Jeanie Bourke - Re: 130 Eastern Promenade - Basement Fire Rating

This email grants approval to supercede the City of Portland stamped plans for building permit #2014-01165, specifically the Floor/Ceiling type #1 at the basement level to not be a rated assembly.

A-1.4

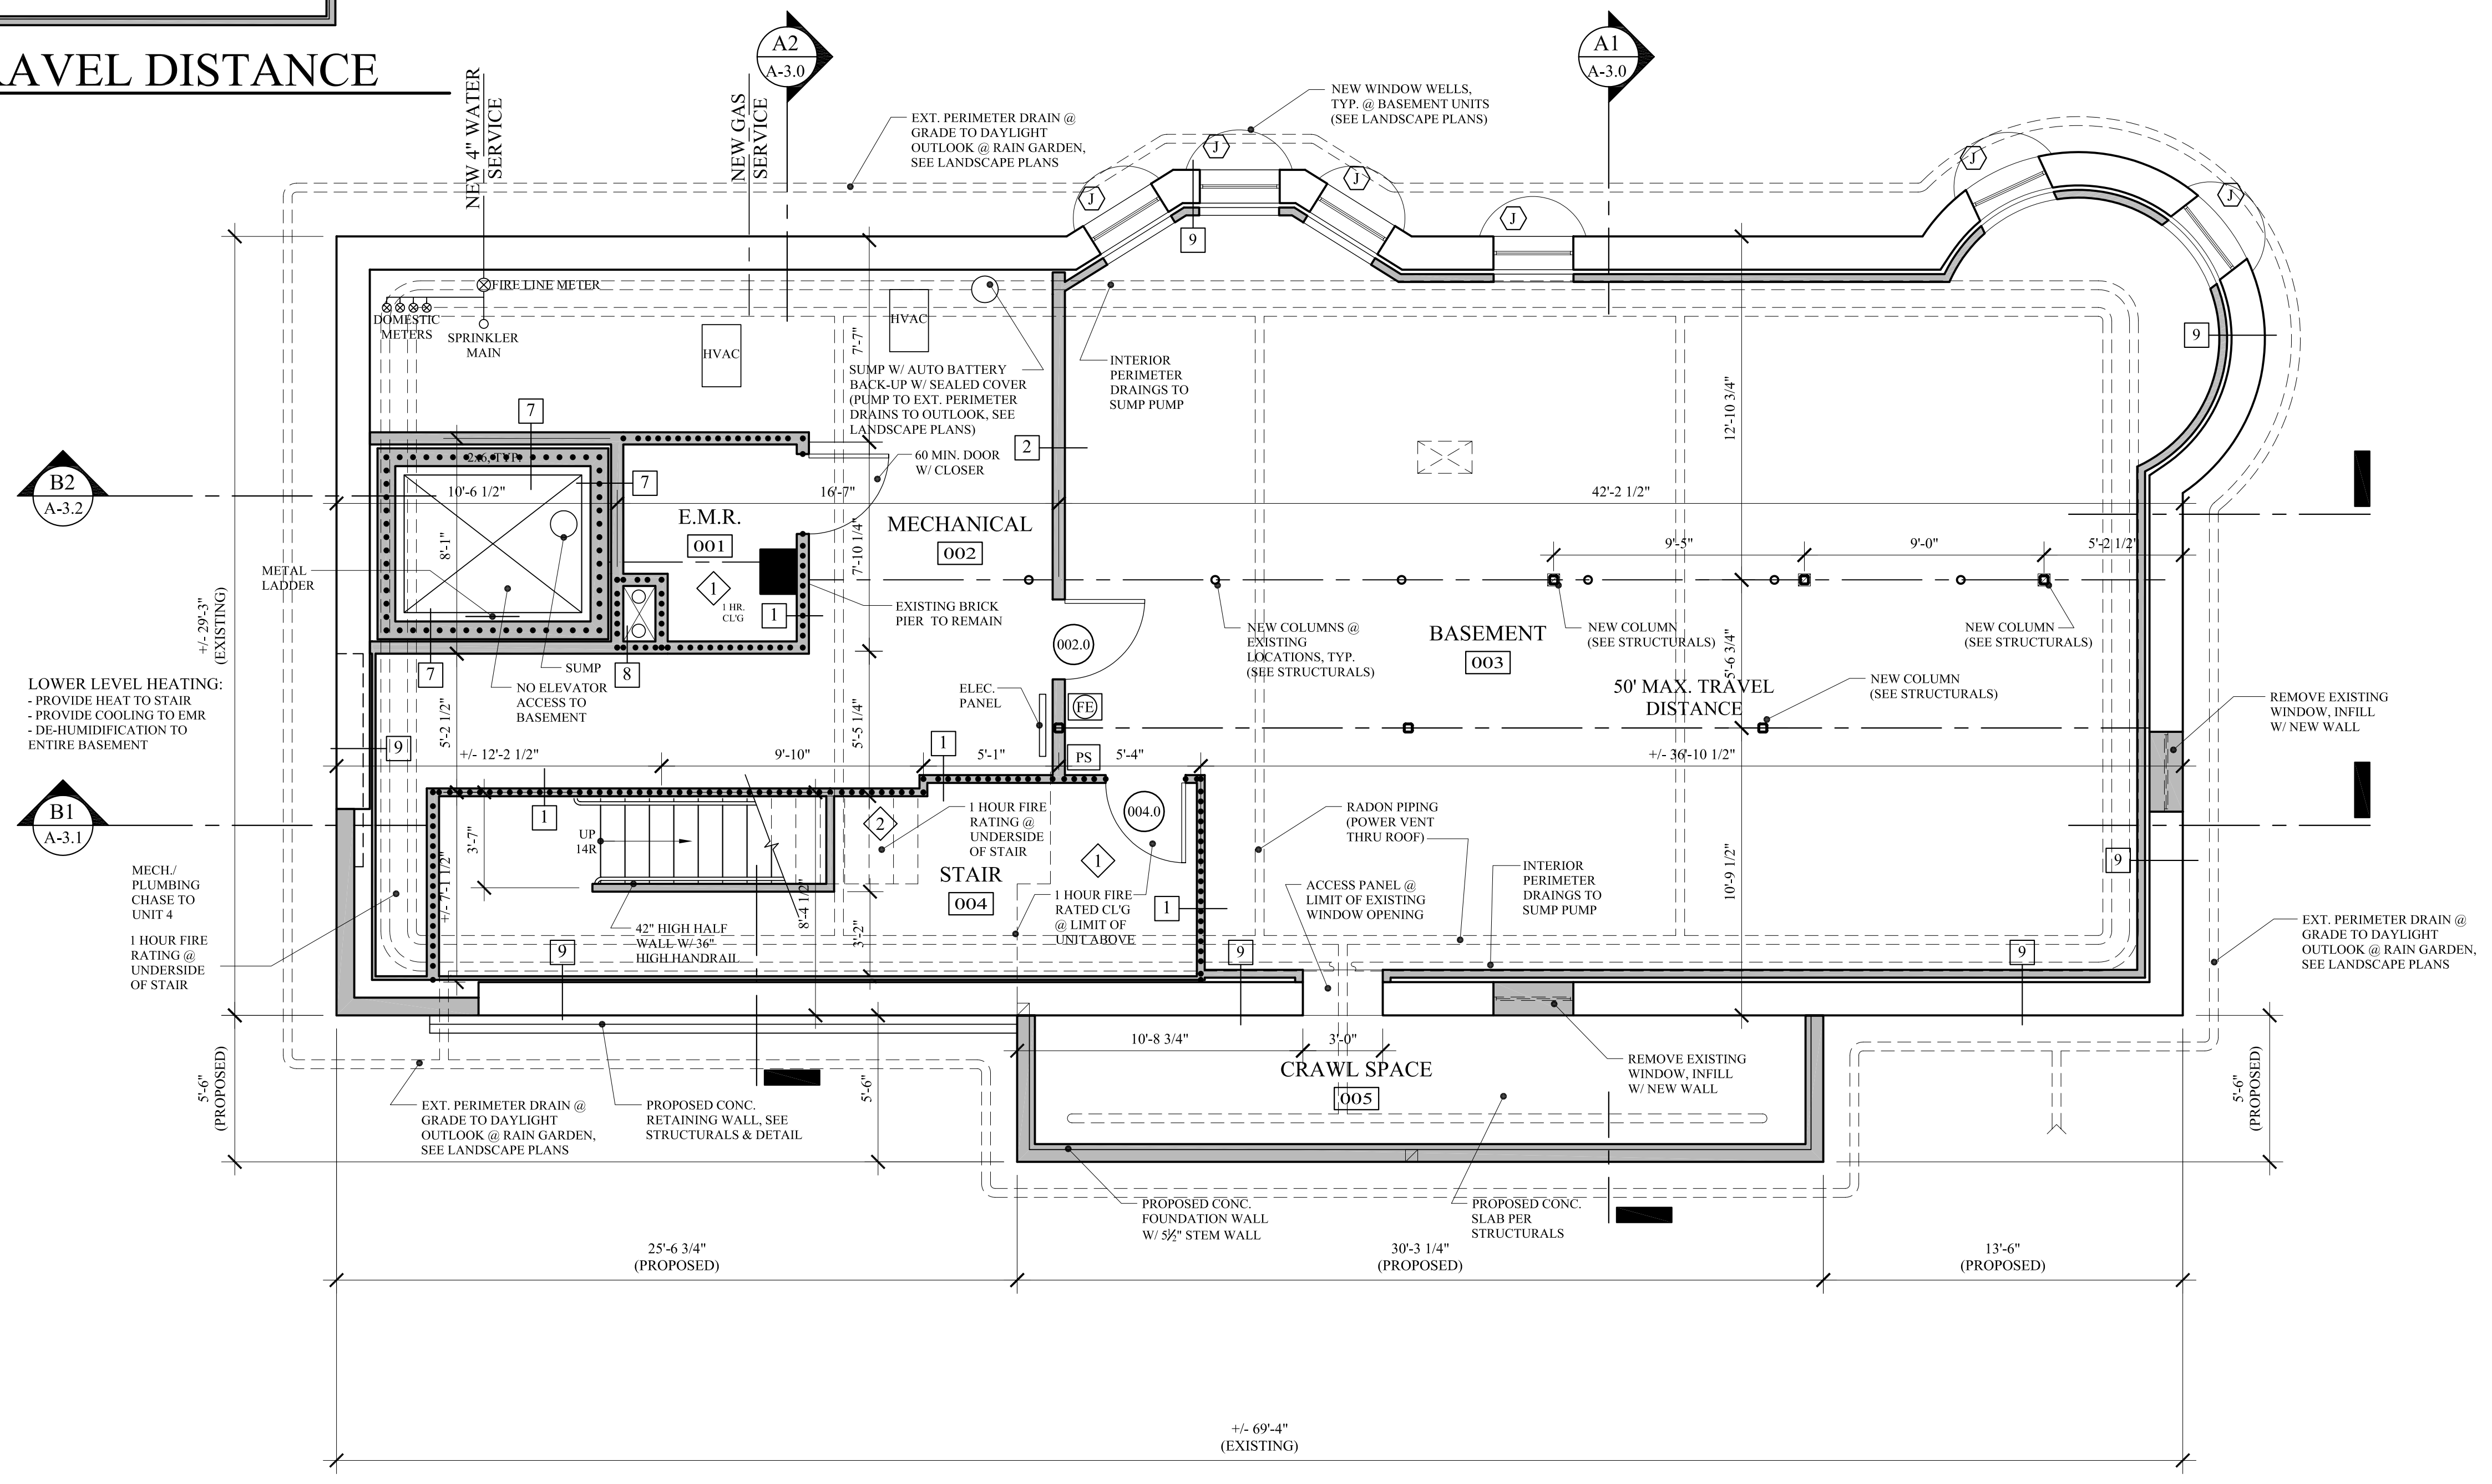
As per our phone conversation today, given the use of the basement and sprinkler system installed we would not be required to have a fire rated ceiling at the basement. If the basement ceiling has spray foam insulation it would need to be protected however. The basement ceiling would still however need to have a smoke rating/ protection; this would all be true for the mechanical room as well.

This response is confirmation of the information below, and to expound, the basement is not occupiable, nor can it be a storage space per the ceiling height requirement of 7' in IBC Sec. 1208.
